**WEST SUSSEX COUNTY COUNCIL
PLANNING SERVICES CONSULTATION**

SUBJECT: WA/68/17/PL - Vehicular farm field entrance.

Land adjacent to The Meads, Barnham Lane, Barnham

Date	Sept 2017	Drawn by	CDP	Scale	as shown
Drawing No.	DPA02	Revision	01

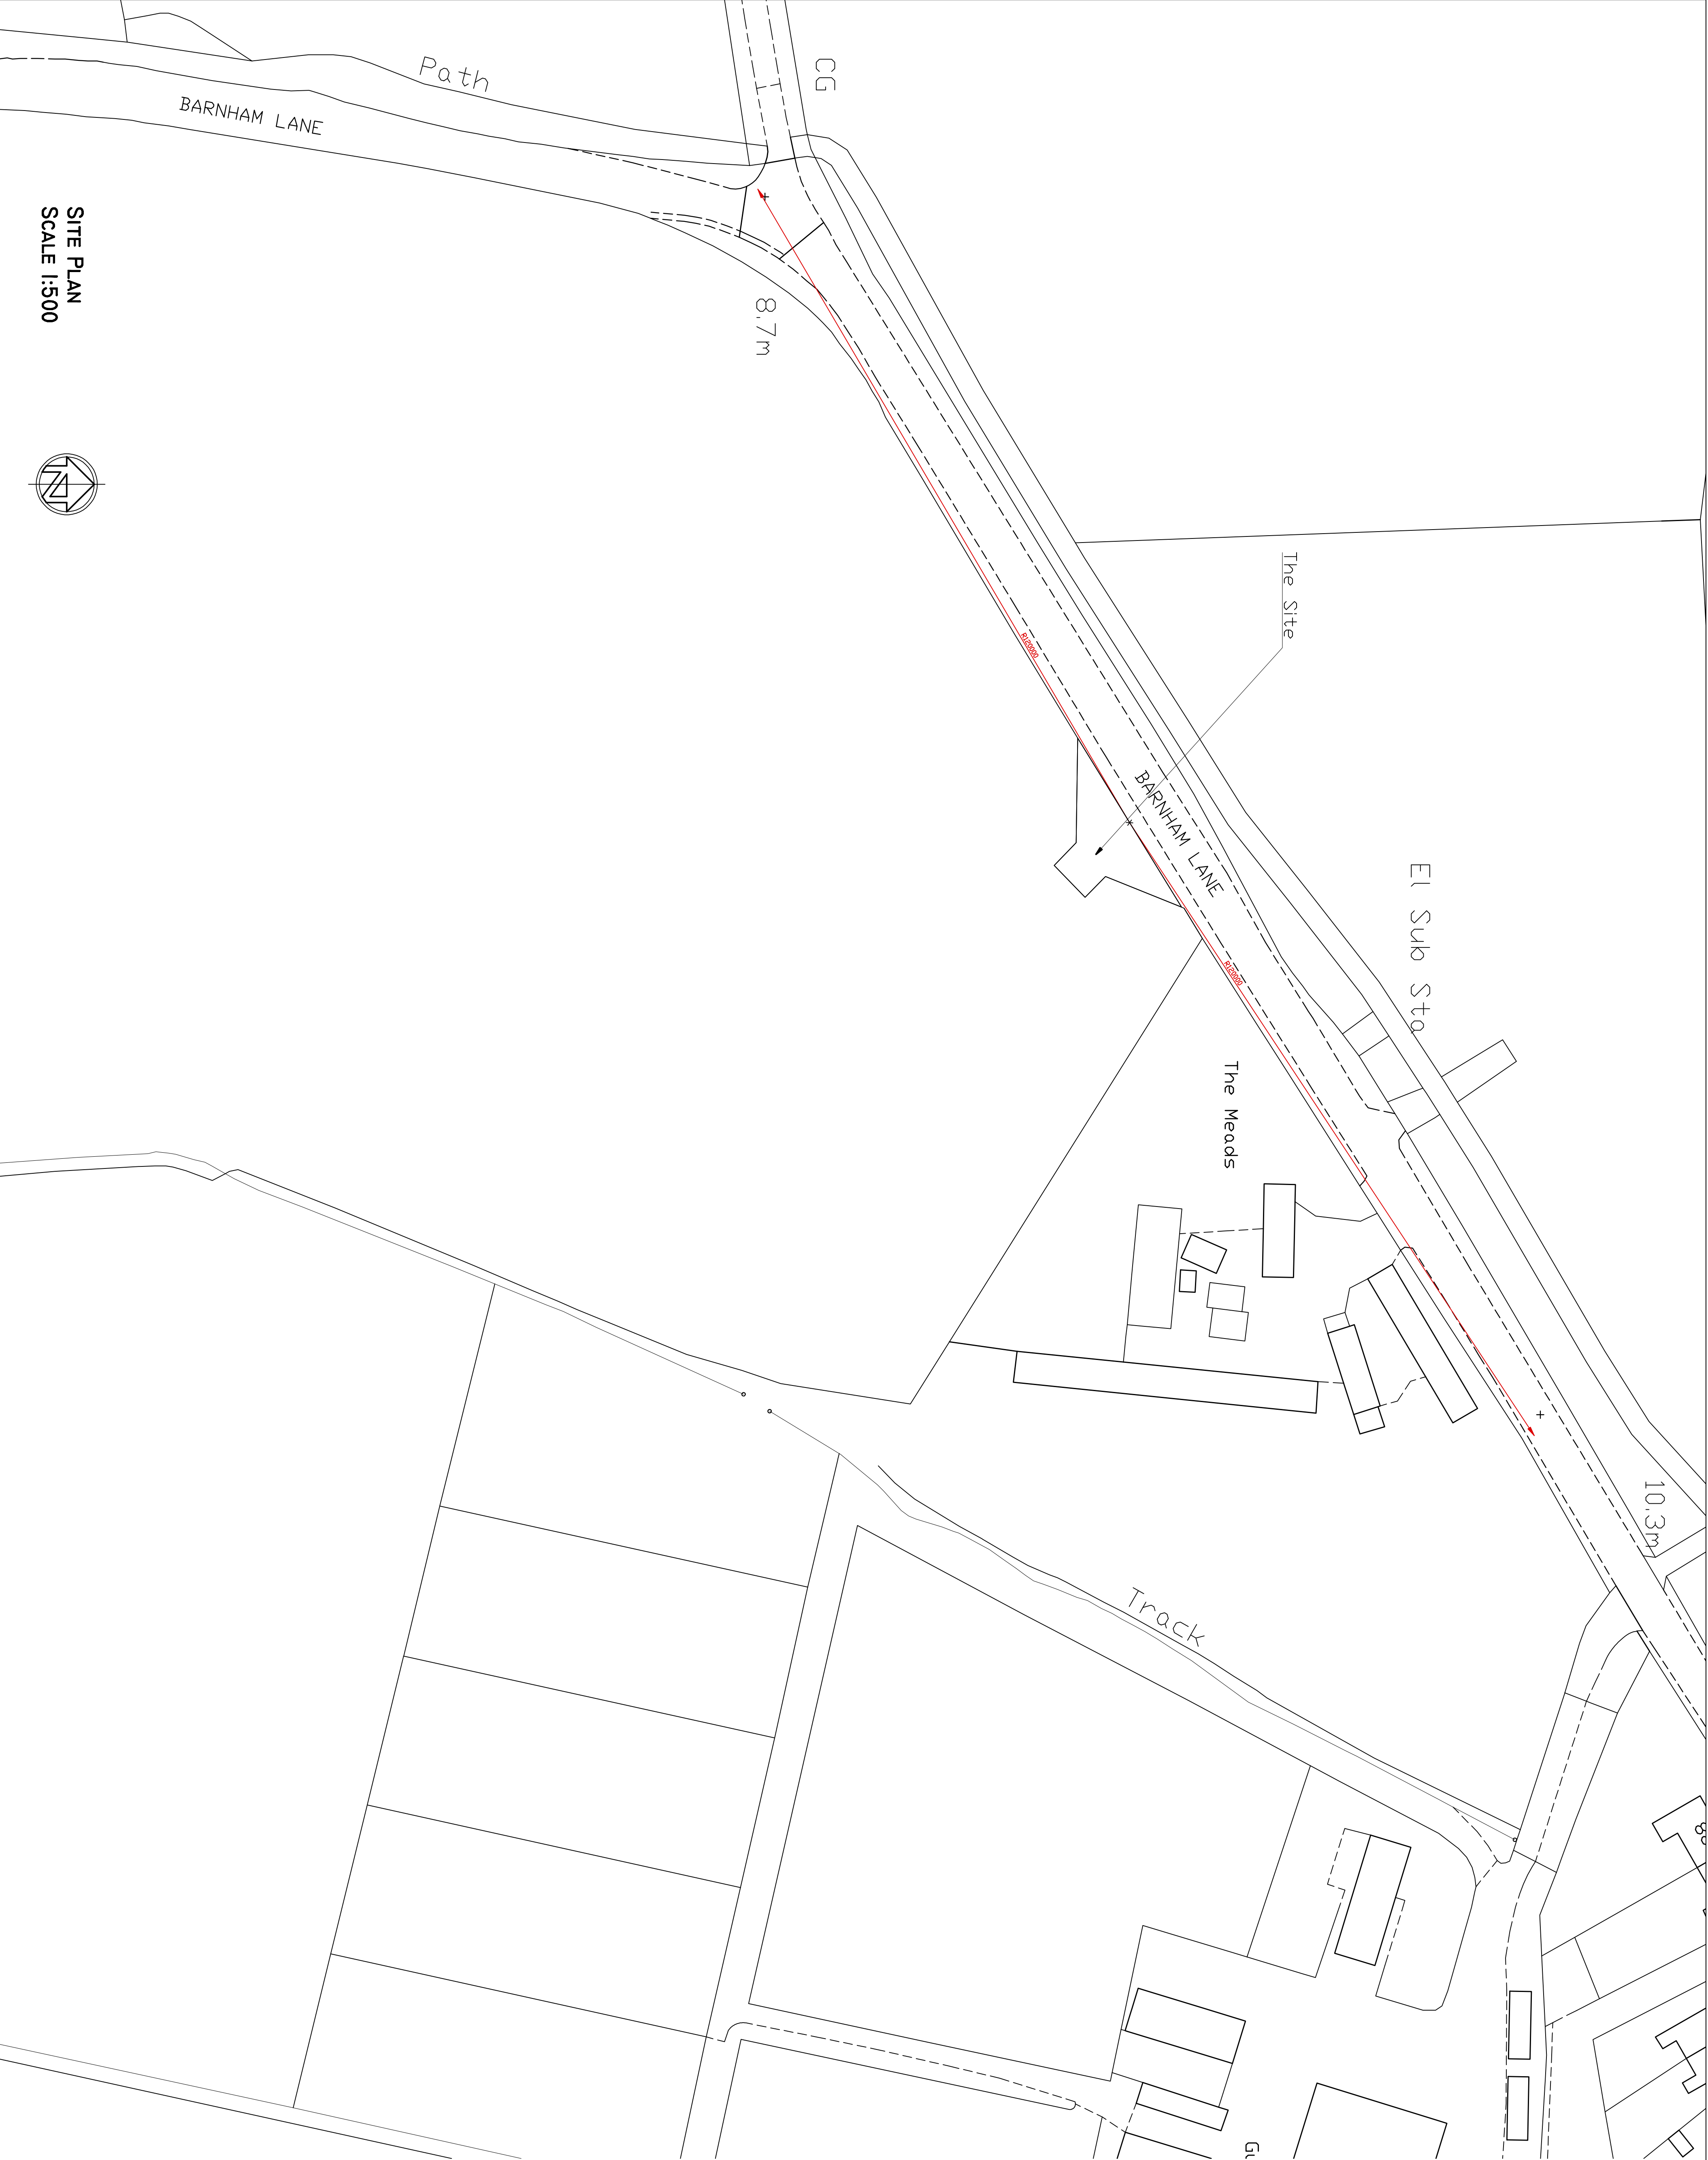
West Sussex County Council was consulted previously on Highway Matters for this application and provided a response dated 23/10/2017. More information was requested from the applicant to demonstrate appropriate visibility splays. Subsequently revised visibility splay plans have been provided, namely DPA-01 02 & DPA-02 01.

After review of the revised plans the applicant has satisfactorily demonstrated that 2.4 x 120 metre visibility splays are achievable using land under their control or that considered to be public highway. Such splays would be considered acceptable for the design speed of Barnham Lane at this point as per the Design Manual for Roads and Bridges (TD/9/93). The Local Planning Authority should be aware that the formation of these splays will have an impact on the adjoining boundary hedging.

The applicant has demonstrated that a 'crossover' will be implemented rather than a 'bell mouth' access. The access works must be implemented under licence to a specification obtained from WSCC Highways. Given the types of vehicles likely to use the access point a heavy duty specification would be advised.

An inwardly opening gate is proposed. The gate is proposed with a 16 metre setback distance from Barnham Lane which would be considered long enough to fully remove a long vehicle from the carriageway while the gate is opened.

The use of the access point shall not commence until visibility splays of 2.4 metres by 120 metres have been provided at the proposed site vehicular access onto Barnham Lane in accordance with the approved planning drawings. Once provided the splays shall thereafter be maintained and kept free of all obstructions over a height of 0.6 metre above adjoining carriageway level or as otherwise agreed.
